FINAL PLAT CHECKLIST

SUBDIVISION TRACTS B-2 AND B-3, Block 8, MESA VILLAGE

SUBDIVIDER TJL, LLC

PLAT OF  
**TRACTS B-2 AND B-3**  
**BLOCK 8**  
**MESA VILLAGE**

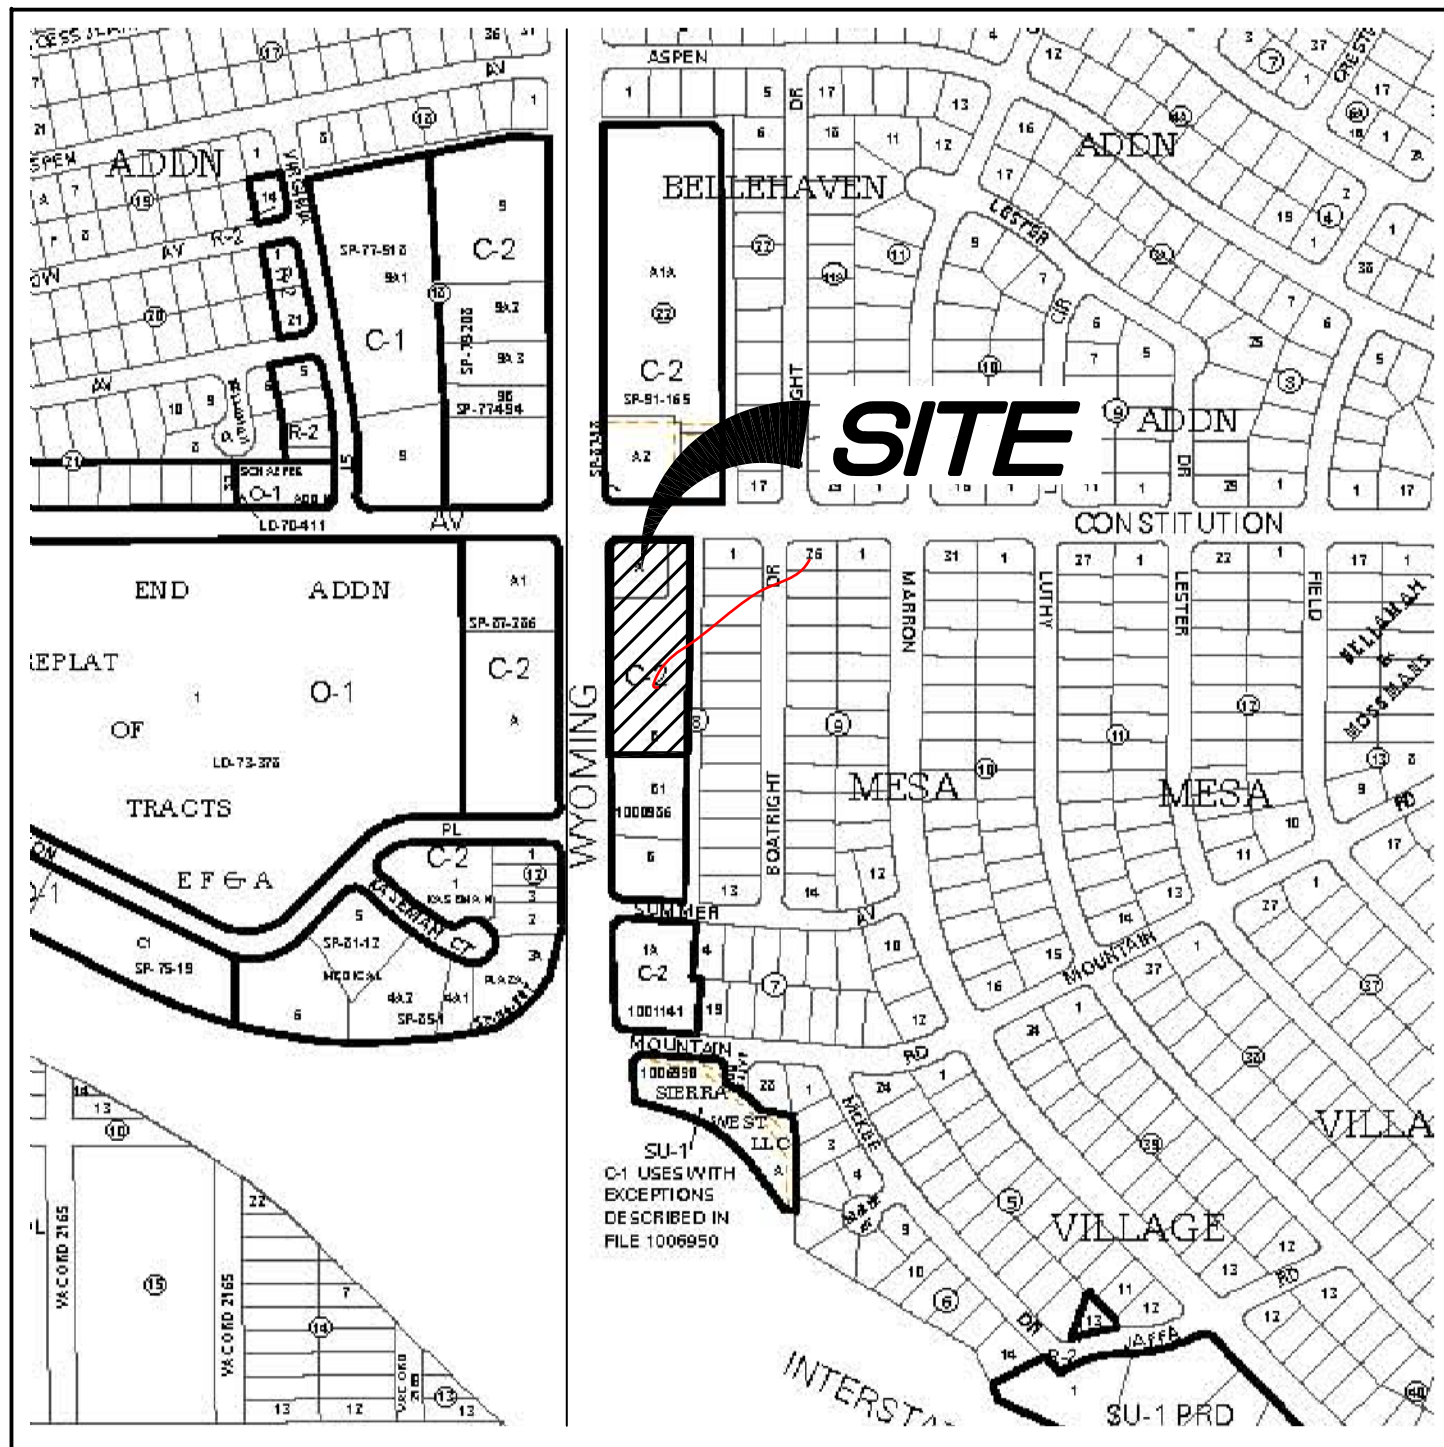
1. Title of Plat AS NOTED
2. Date of Plat _____
3. Scale, Equivalent and Graphic _____
4. North Arrow _____
5. Zone Atlas Index Number _____
6. Location Map. Scale and North Arrow _____
7. Reference to:
 - a. Federal Section ✓
 - b. Projected Section AS NOTED
 - c. Land Grant AS NOTED
 - d. Albuquerque Geodetic Reference System ✓
8. Purpose of Plat _____
9. Solar note _____
10. Bulk Land Variance note N/A

SHEET 3 OF 3

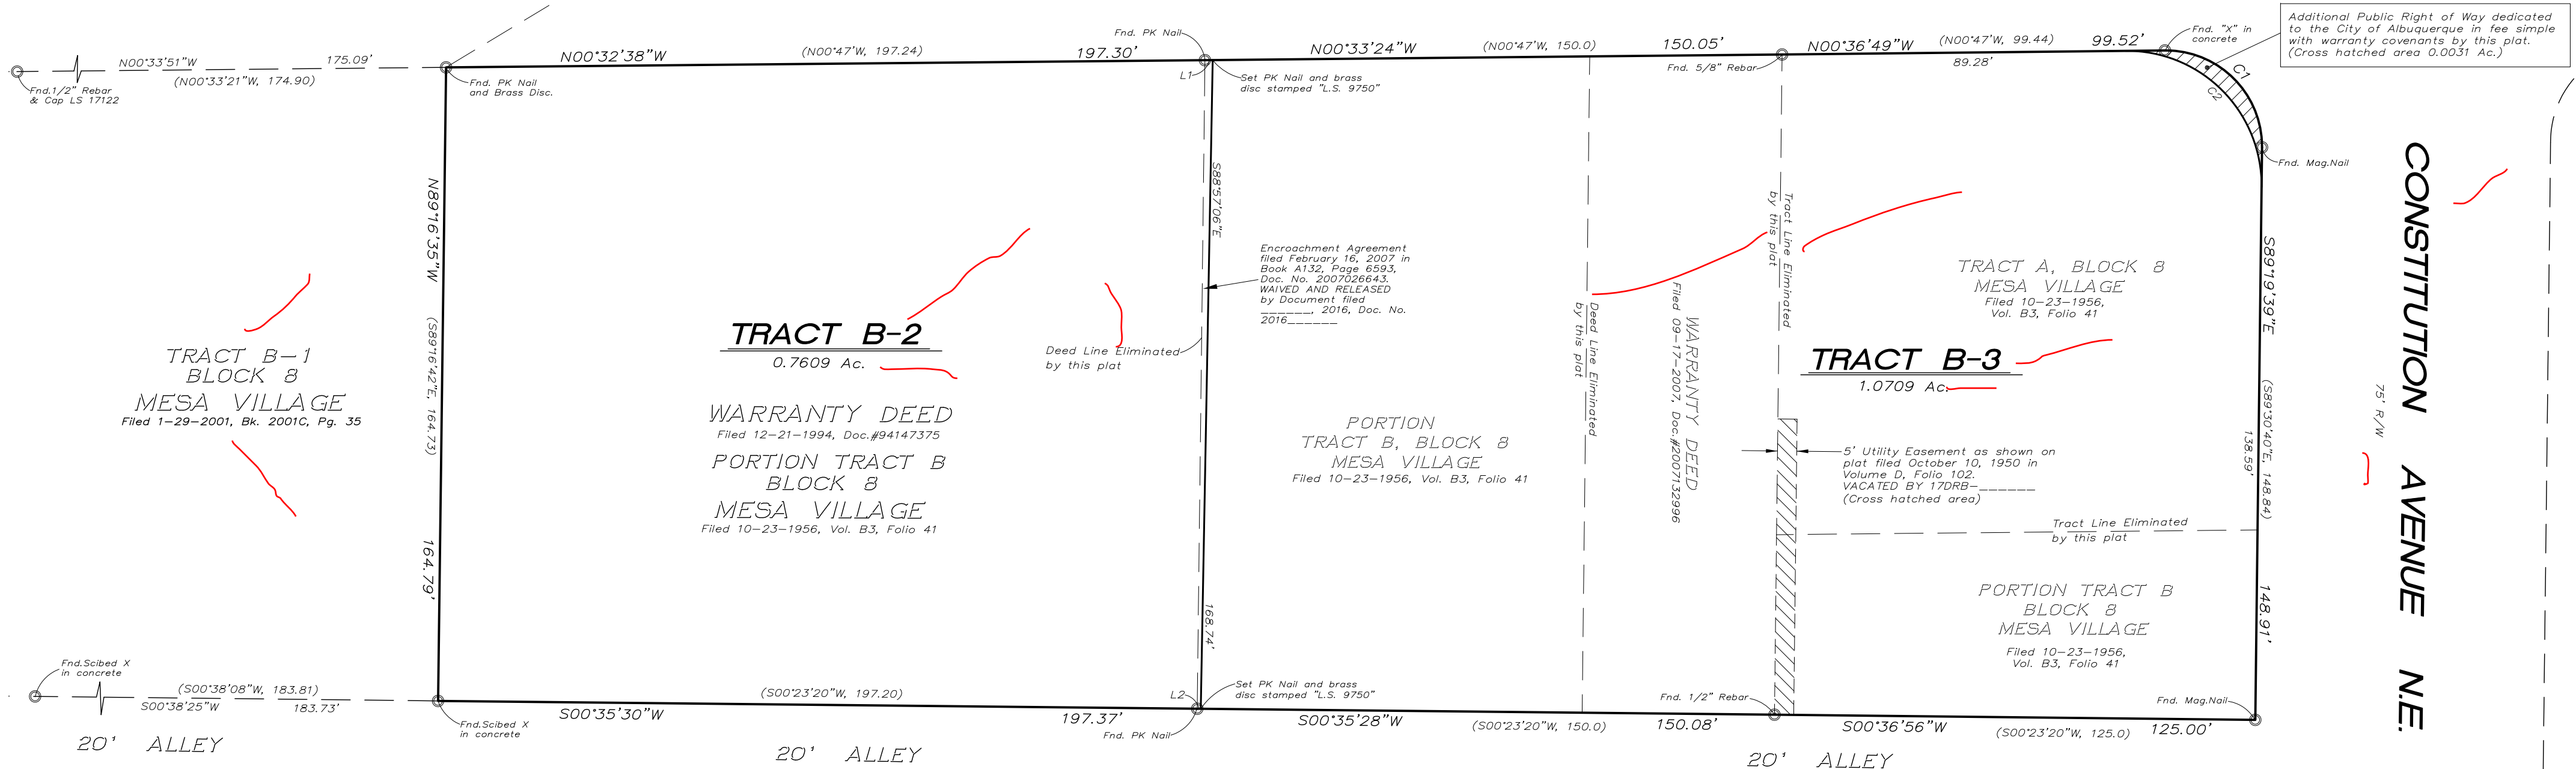
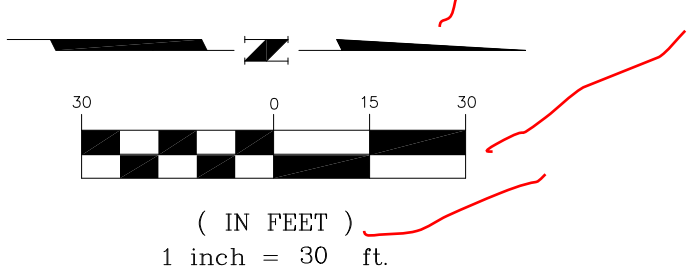
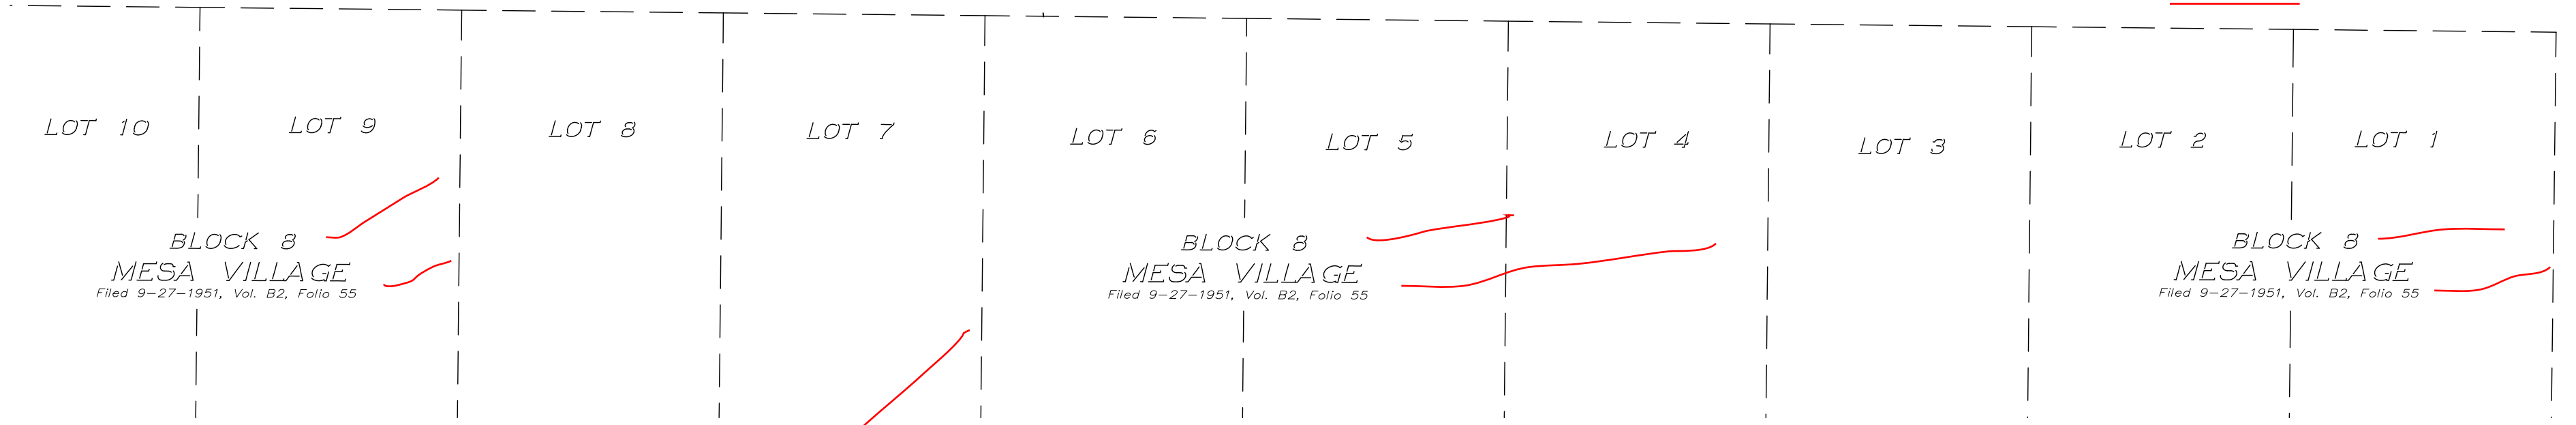
- 1. Written Description, Metes and Bounds _____ **AS NOTED**
- 2. Bearings in Degrees, Minutes and Seconds _____
- 3. Distances in Feet and Hundredths of a Foot _____
- 4. Record Distances and Bearings _____
- 5. Total Gross Acreage of Subdivision _____
- 6. Basis of Bearings : NMSP Grid or Rotation Factor to Grid _____
- 7. Property Corners Found or Set _____
- 8. Property Lines Eliminated Shown as Dashed Line _____

- 1. Definitive Statement Regarding Easements of Record, or Basis of Easements Shown on Plat _____
- 2. Location by Bearing and Distance _____
- 3. Dimension _____
- 4. Purpose _____
- 5. Proposed: Dashed Lines and Labeled _____ NONE SHOWN
- 6. Existing: Dashed Lines and Labeled with Recording Data _____
- 7. Vacated: Ghost Lines and Labeled _____
- 8. Apparent: Shown and Labeled _____
- 9. Limitations _____
